22 December 2015

File No: R/2015/14/A
Our Ref: 2015/672595

RE: SSD 7056 – Remediation, Renewal and Adaptive Re-Use of “The Campbell’s Stores”, 7-27 Circular Quay West, The Rocks

Section Title
SECTION - BAY 12 SOUTH

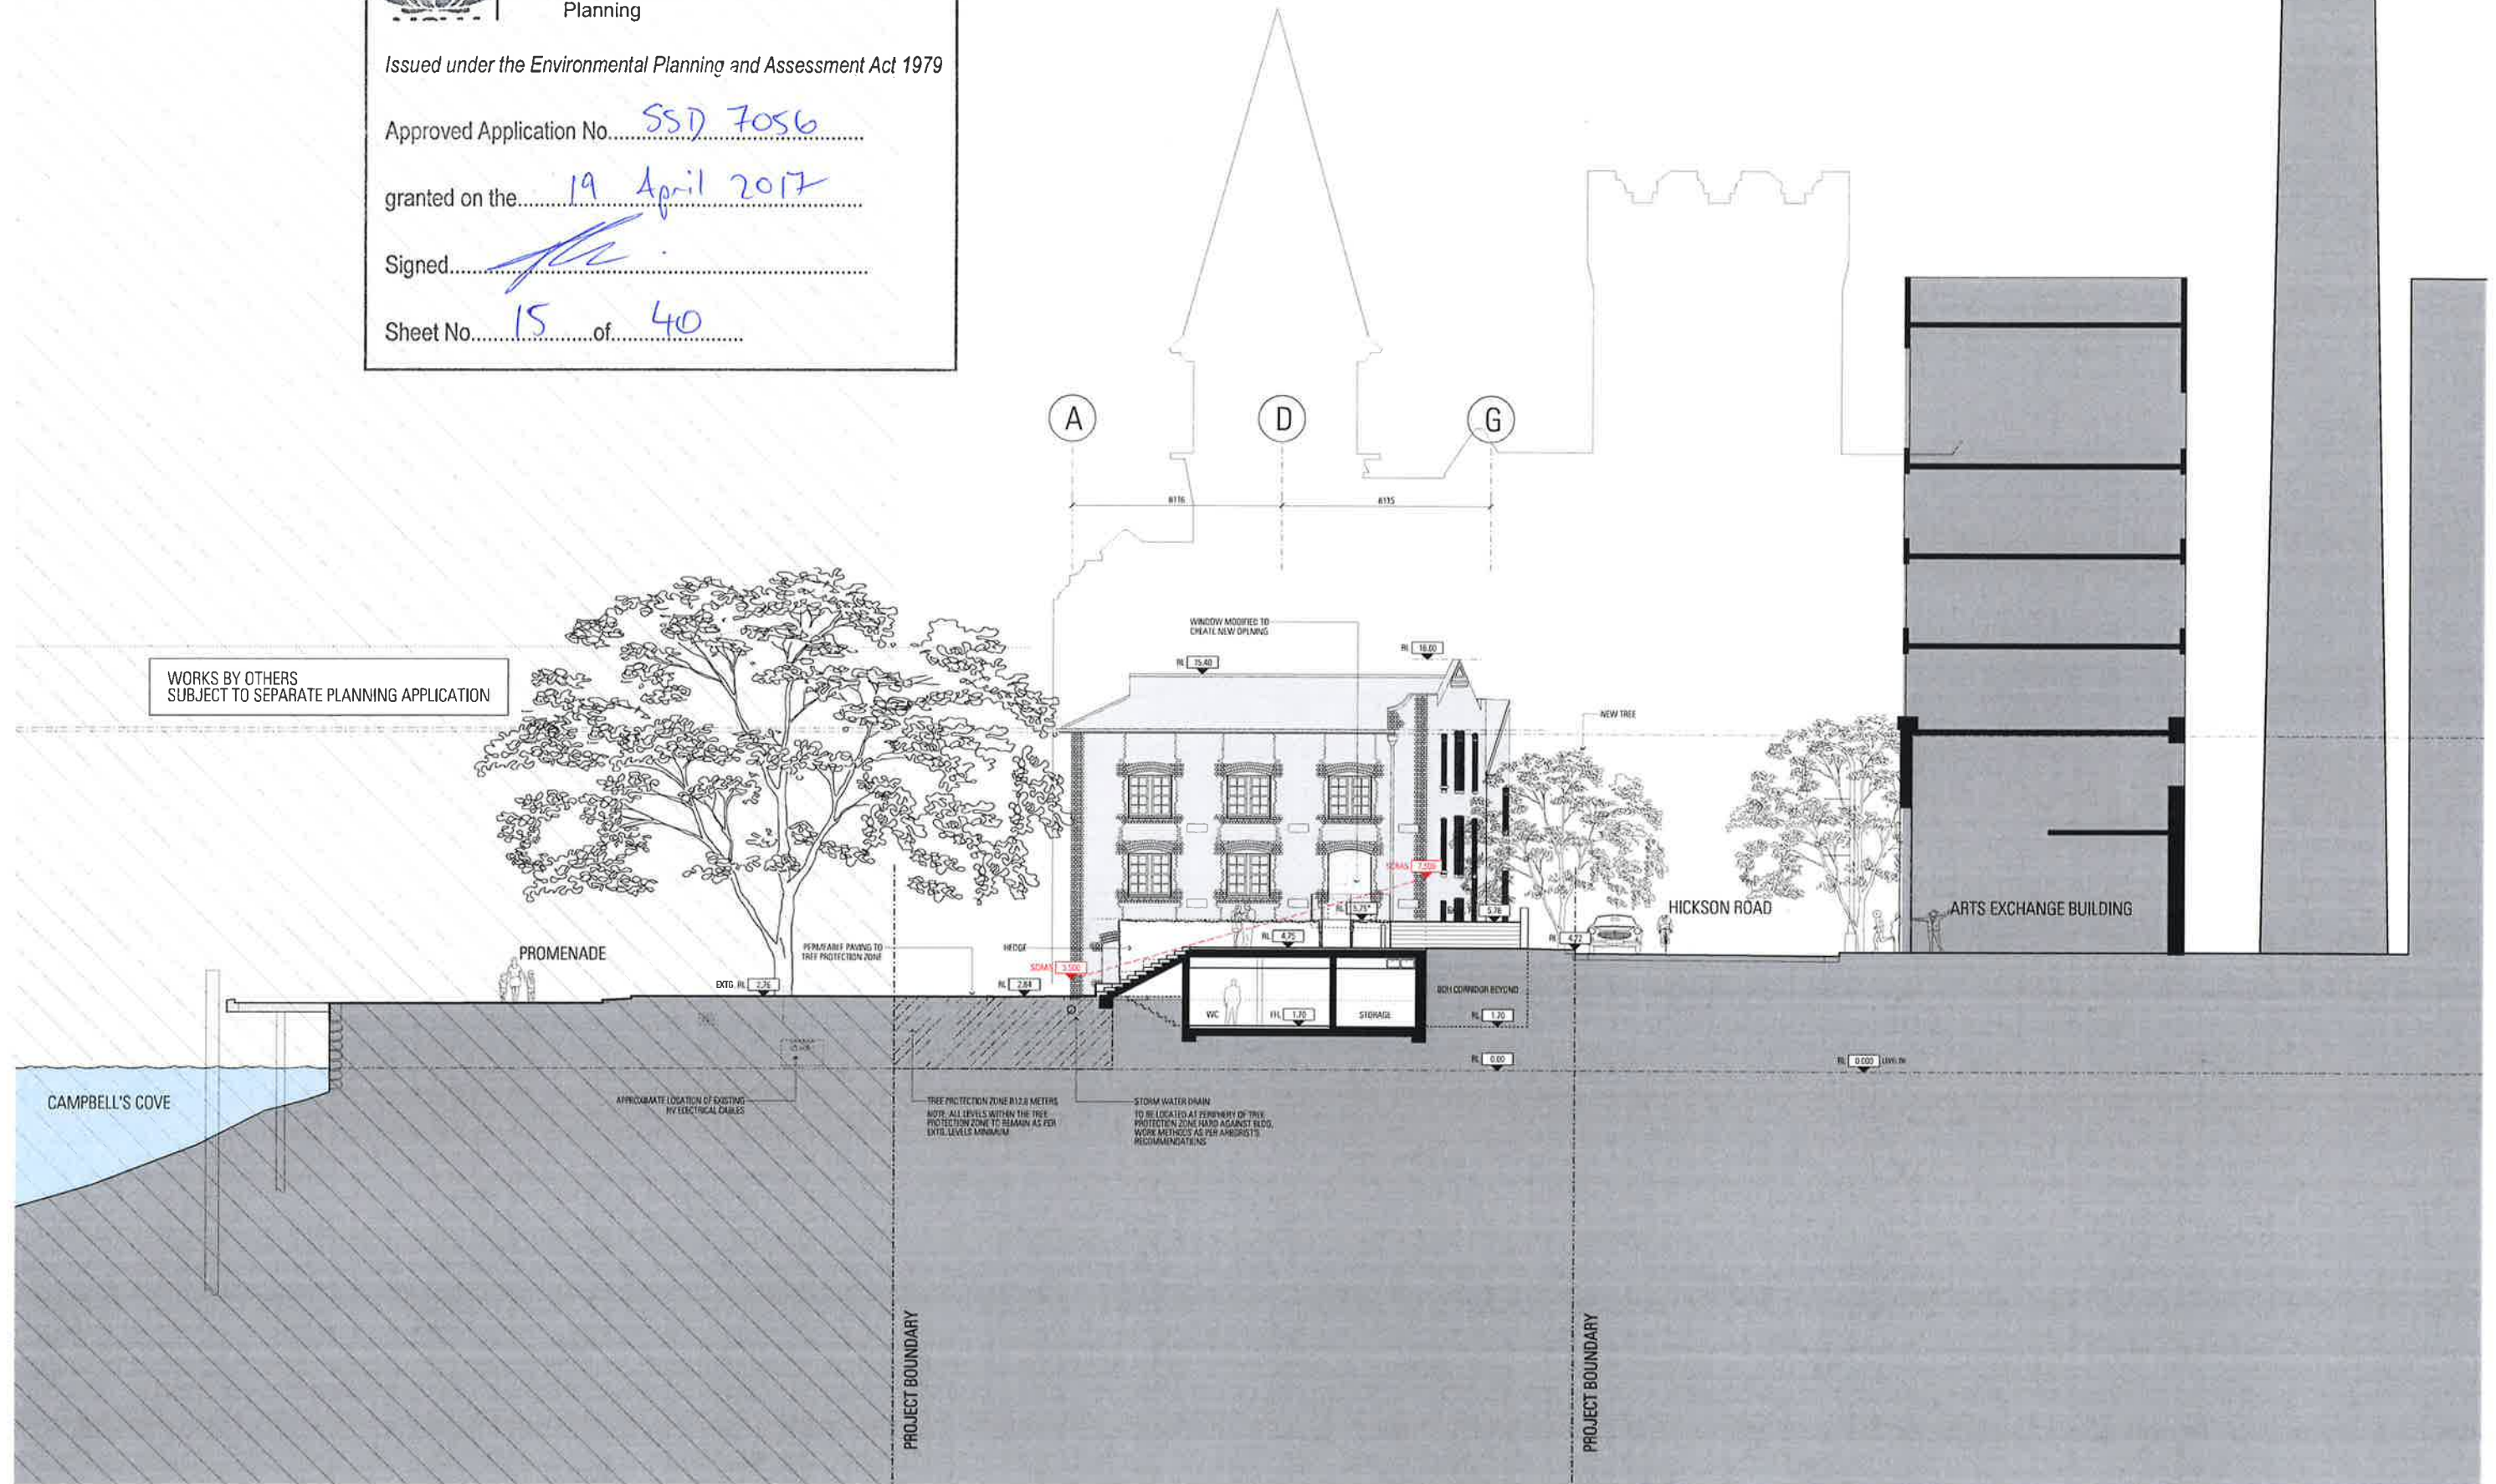
The roof and underside of the soffit to the northern “Bay 12” building need to be approached as fifth and sixth elevations of the building due to their high visibility from the public domain and surrounding buildings. The materials and finishes will need to be high quality. Glass floors or glass blocks in the floor of the building, visible to pedestrians looking up, is unlikely to be resolved satisfactorily. Lighting requires careful integration with the soffit. Public art opportunities are present.

Plans, elevations and renders are not aligned and require greater coordination. For example, the glass block finish for the “Bay 12” building is shown in the round in most images. However, internal renders show large slotted windows for views to the Opera House and back to Campbell’s Stores. These slot windows have a very different architectural styling to the glass block vision. Clarification should be provided on the direction and objectives for the building.

The Department should carry out an independent view loss assessment for properties to the west of the proposed “Bay 12” building. A fundamental consideration of the assessment is the reasonableness of the proposed height of the building, including lift overrun, service risers and plant, when considered against the Sydney Cove Redevelopment Area Scheme. While the structure, subject to the Department’s other assessment consideration, may be found to have reasonable visual, heritage, sustainability and other impacts, the view loss assessment may show unreasonable impacts from non-compliance with the planning controls.

The internal renderings of the Bay 12 building include clear glazed windows that indicate a framed view of the Opera House. The structure therefore is likely to block rather than share this view with properties to the west.
